# CITY OF ALBUQUERQUE

December 2, 2019

**Re: Play House Tenant Improvement**  
**5201 Ouray Rd NW**  
**30-Day Temporary Certificate of Occupancy**  
**Transportation Development Final Inspection**  
Engineer's/Architect's Stamp dated 11-22-19 (H11D059D)  
Certification dated 11-22-19

TRAFFIC
CIRCULATION
LAYOUT

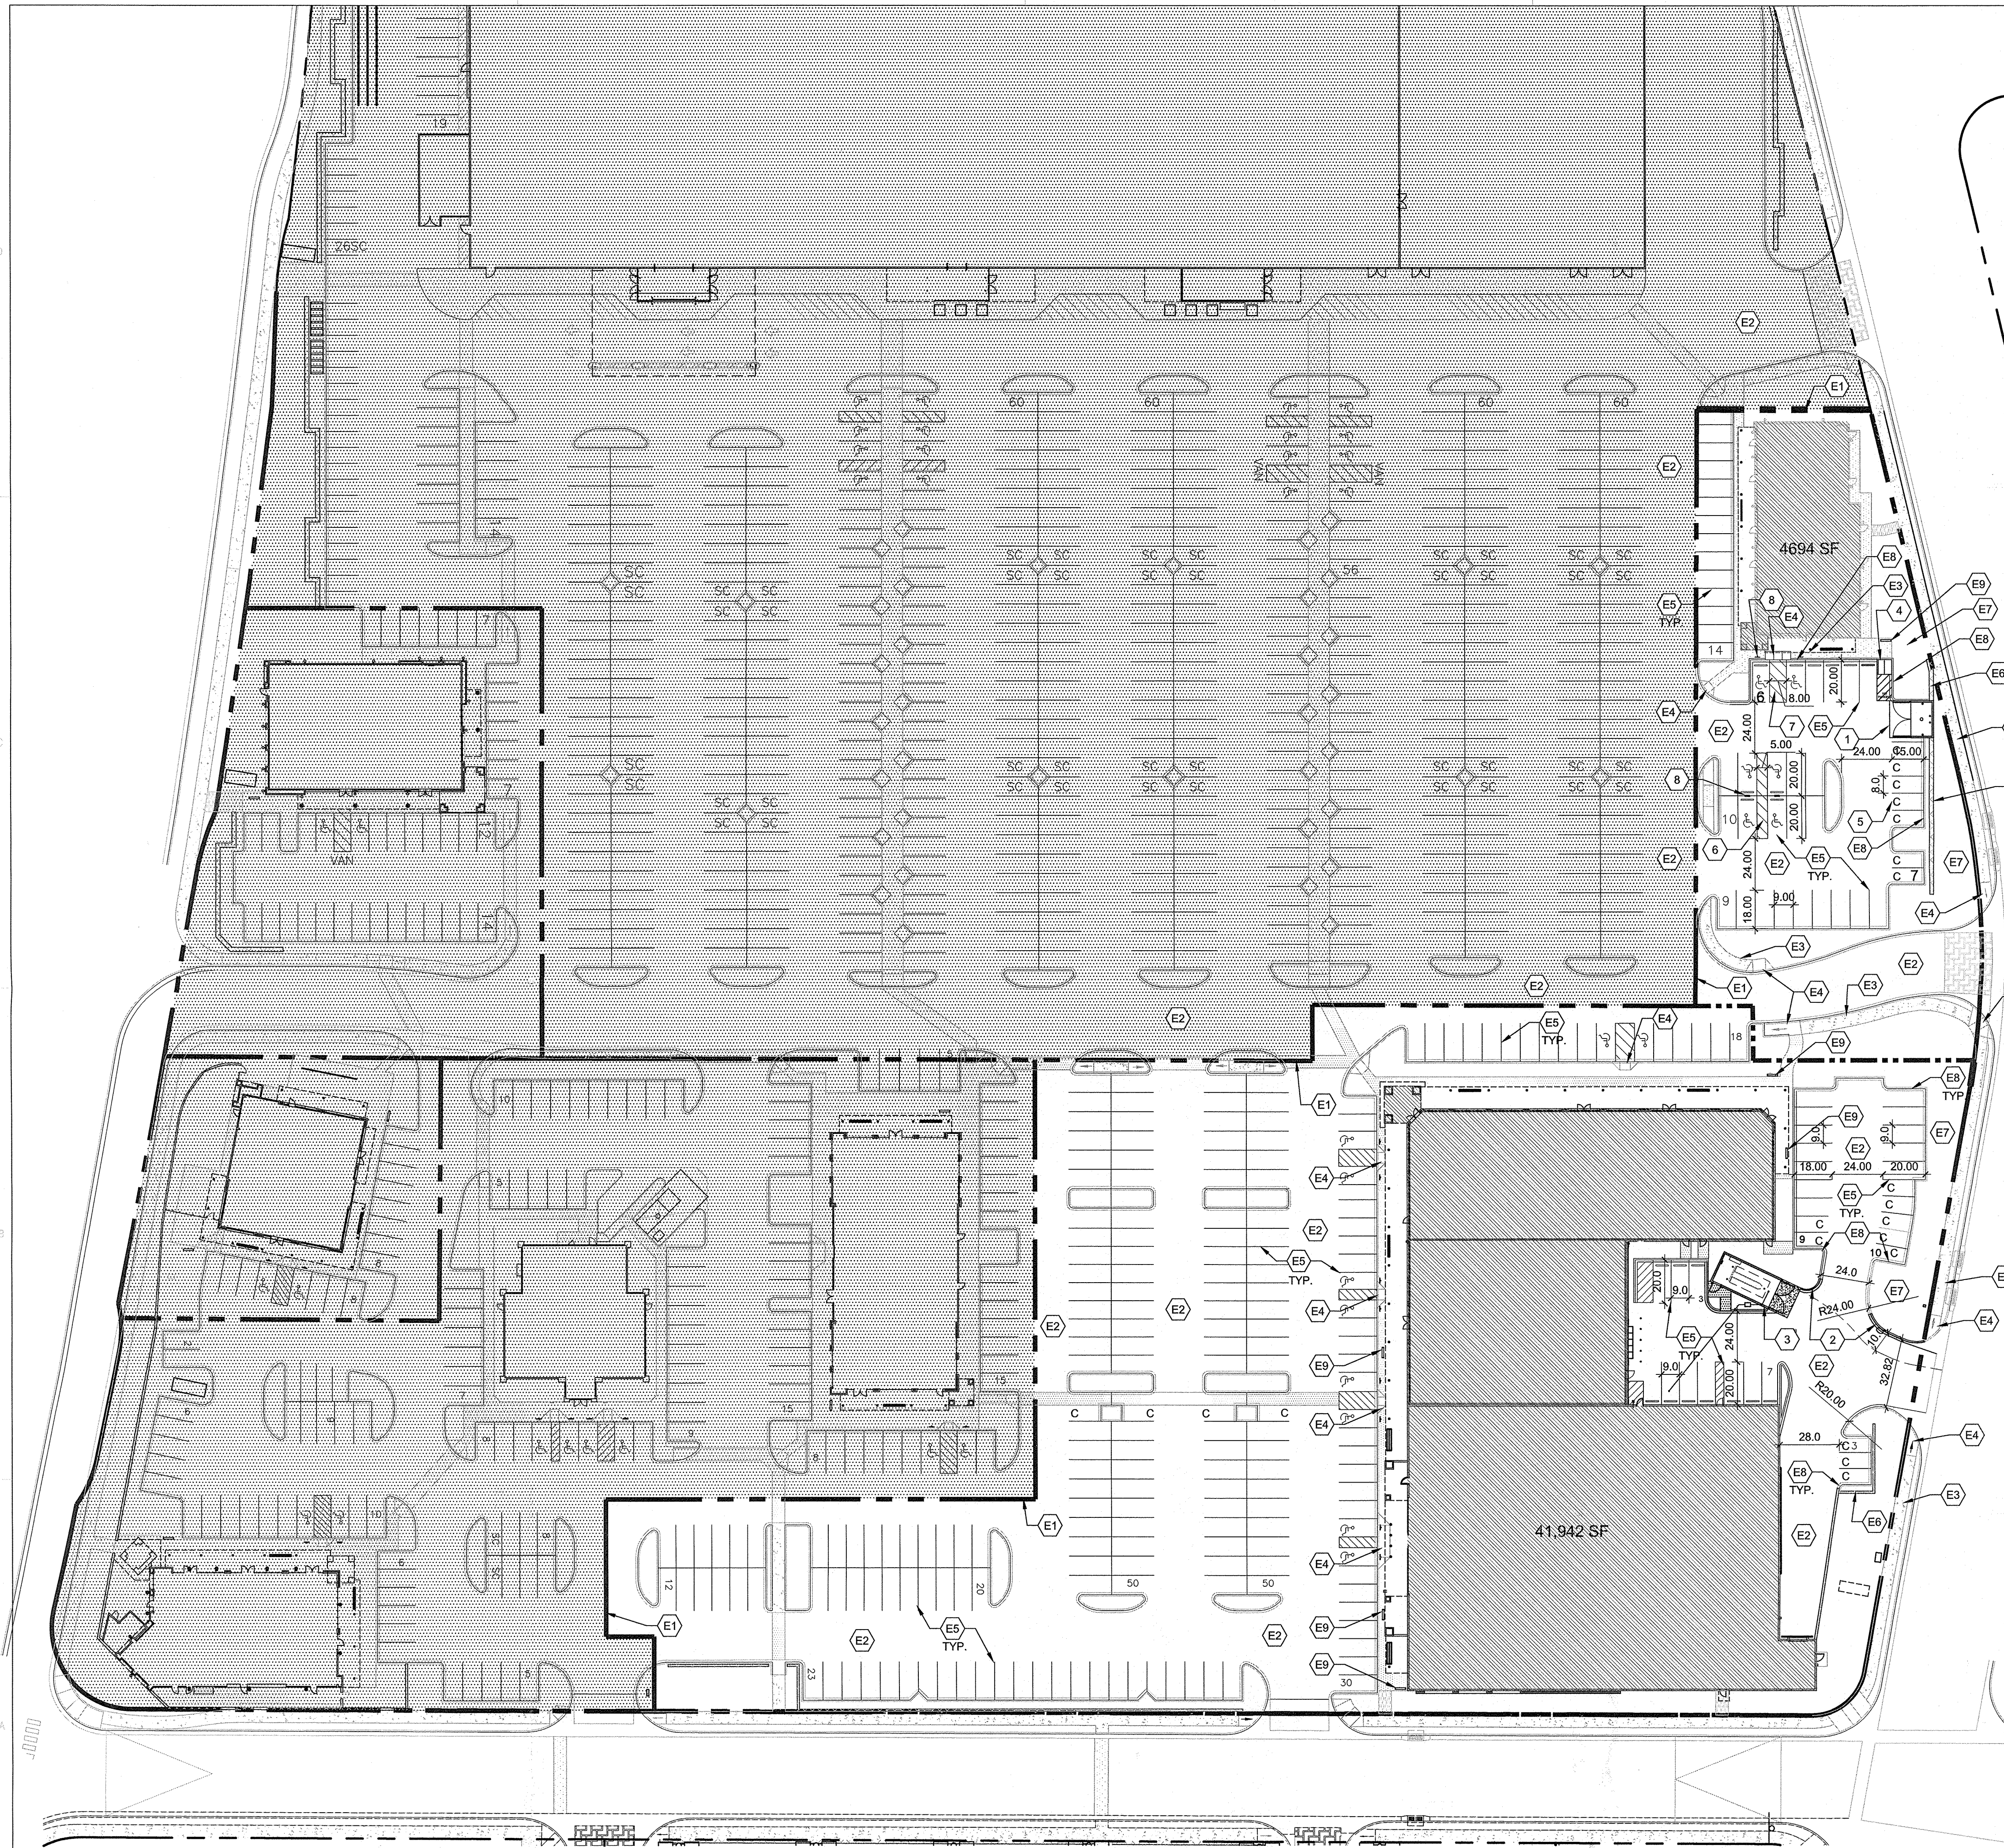
1. The ADA accessible parking sign must have the required language per 66-7-352.4C NMSA 1978 **"Violators Are Subject to a Fine and/or Towing."** Please call out detail and location of HC signs. Please update ADA Signs to reflect current language.
